Job: Weaver Development – Lot 2 McPhail Farm / Harnett Co.

Concern: 3-Ply Girder Truss / Gap Between Plys

### Truss Placement Plan SCALE: NTS

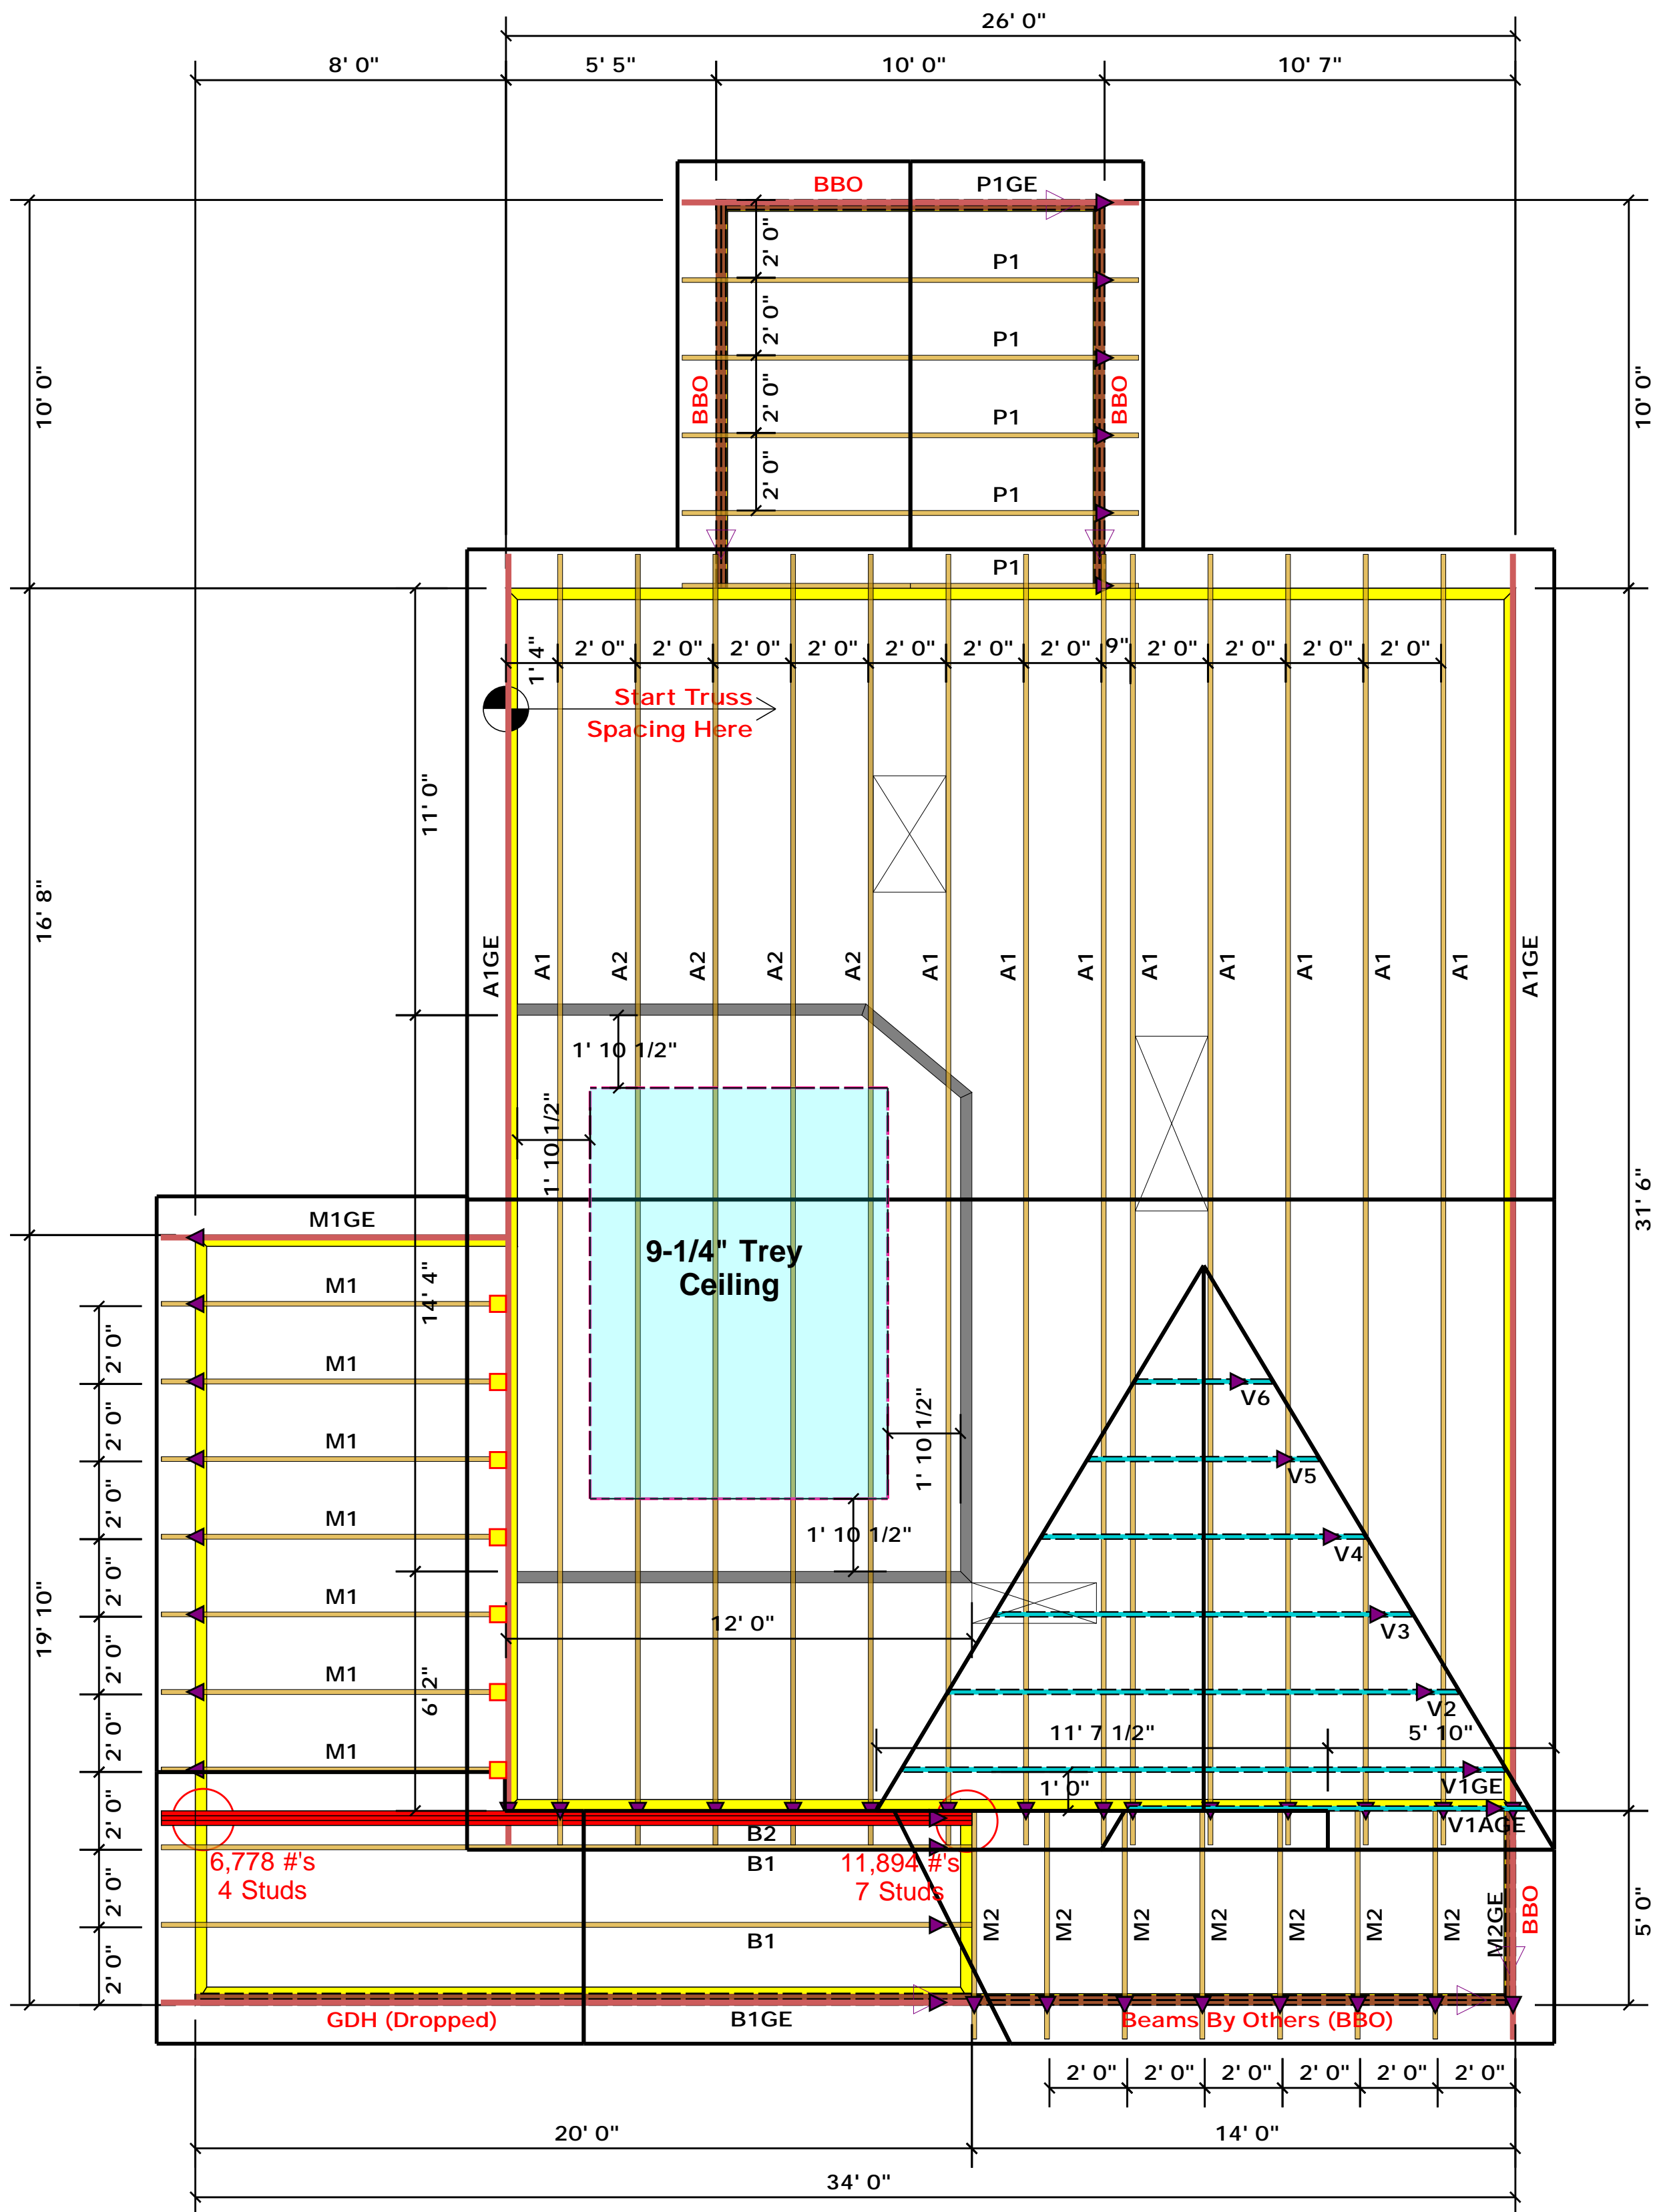
The Concern is for the 3-PLY Girder truss "B2" not attached together properly. Builder has applied bolts to pull truss plys together eliminating the excessive gap in girder truss "B2". The truss now looks to be properly nailed and bolted together.
